Pre-lodgement Advice Meeting

PROPERTY:	Culburra Rd Culburra Beach – Lot 2 DP 1279350 9 Strathstone St Culburra Beach – Lot 1 DP 631825
FILE REFERENCE:	75459E/4
MEETING DATE:	20 June 2024
MINUTE DATE:	24 October 2024
COUNCIL OFFICER ATTENDEES:	Justin Lamerton – Senior Development Planner Scott Haylett – Development Engineering Andrew Solari – Shoalhaven Water Alex Aronsson – Floodplain Management Paul Donnelly – Open Space & Recreation Ben Coddington – Biodiversity Gordon Clark – Strategic Planning
EXTERNAL ATTENDEES:	Rebecca Lockart – Allen Price & Scarratts Pty Ltd Ryan Howes – Allen Price & Scarratts Pty Ltd Matt Philpott – Sealark Pty Ltd Andrew Norris - Martens
ADDRESS FOR MAILING:	rebecca@allenprice.com.au

Councils Understanding of the Proposal	<i>Concept Development Approval</i> SSD 3846 was approved as a Concept Development Approval (per s4.22 of the Environmental Planning & Assessment Act (EP&A Act) 1979) by the Land and Environment Court on 1 December 2021 (LEC No: 2019/78149). Assessment of future development applications must not be inconsistent with the conditions of the Concept Approval. <i>Proposed Modification to Concept Development Approval</i> A separate S4.56 mo

PROPOSED MIXED USE CONCEPT PLAN - SHARED FOOTPATH PLAN

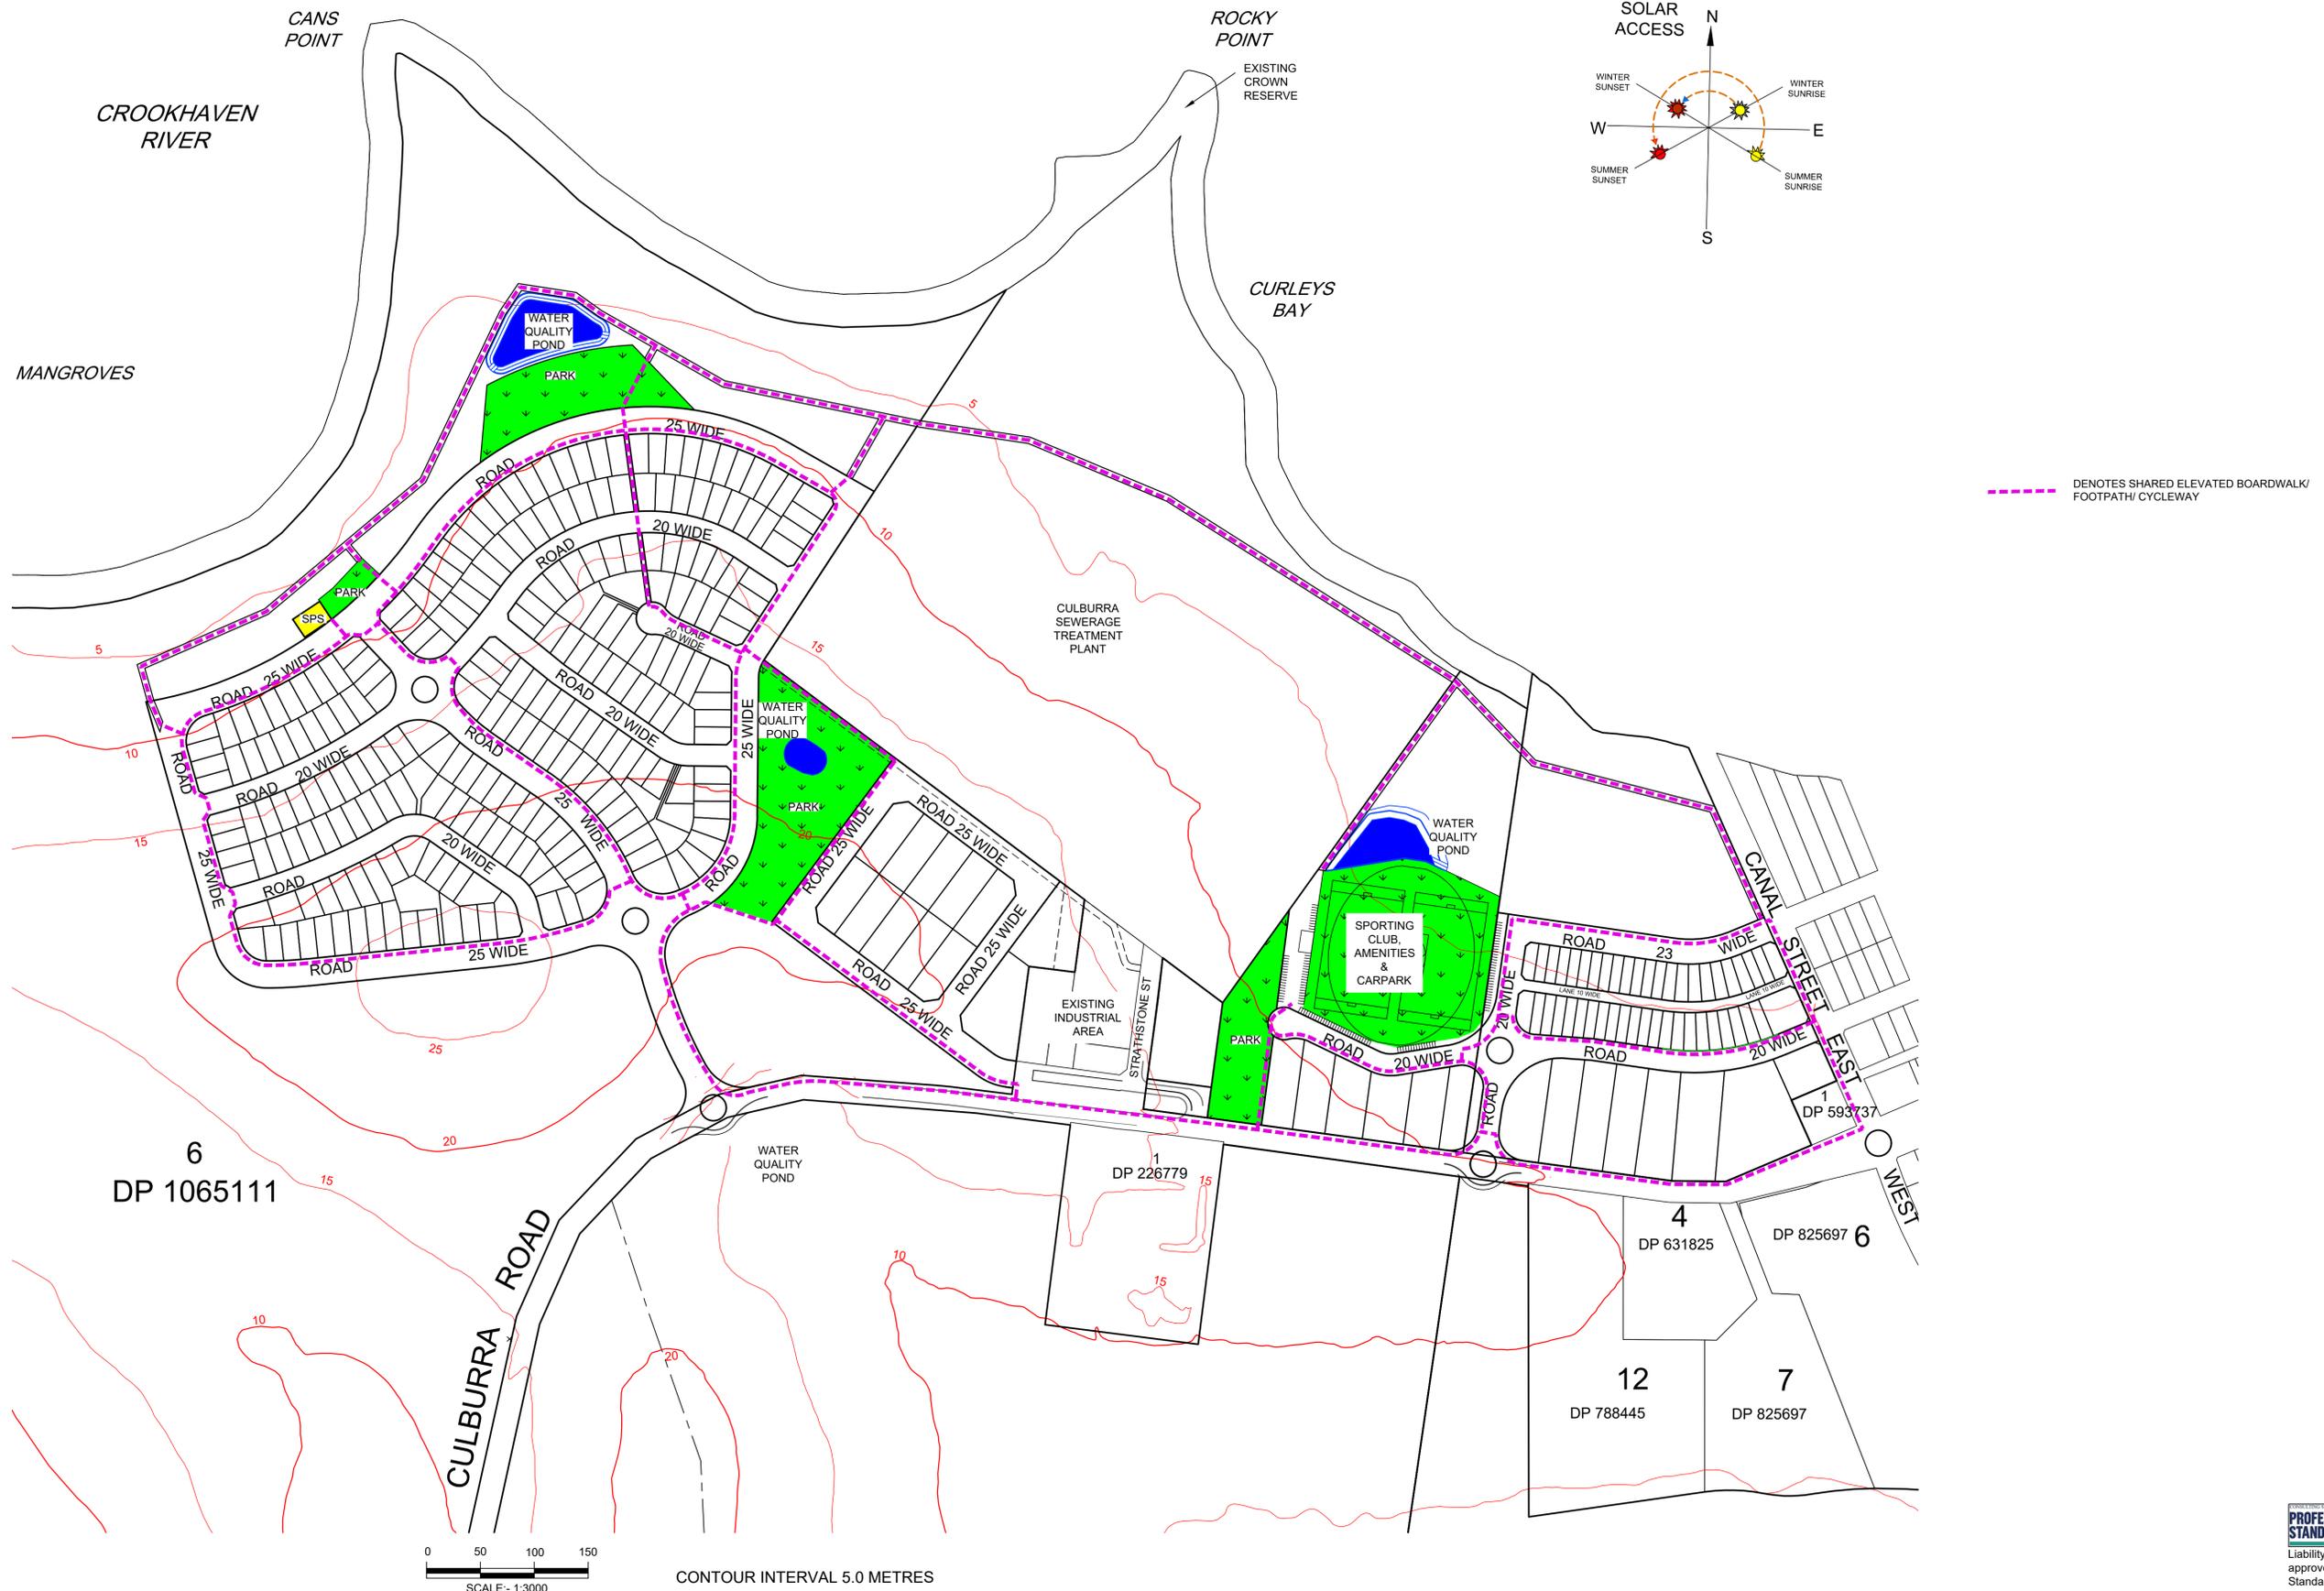
Shared Footpath (Dwg. 25405-221 Rev 2)

With reference to APS Statement of Commitments – Infrastructure (Footpaths):

- Provide amended documentation (plans and sections) clearly illustrating:
 - Pedestrian footpaths to all verges with residential lot frontages (both sides to Road 01, Road 03, Road 04, Road 05, Road 06;)
 - Provide pedestrian footpaths on verges with lot frontages on Road 02.
- With reference to Condition B51, Table 2, ESD requirements, a shared user pathway should be provided to all verges, adjacent to open spaces to Road 02 and be connected to the Spine shared pathway to Road 01.
- Provide amended documentation (plans and sections) clearly illustrating:

Safe and convenient pedestrian crossing points to all internal road intersection, including locations for concrete ramp turn downs and any other requirements of Shoalhaven City Council.
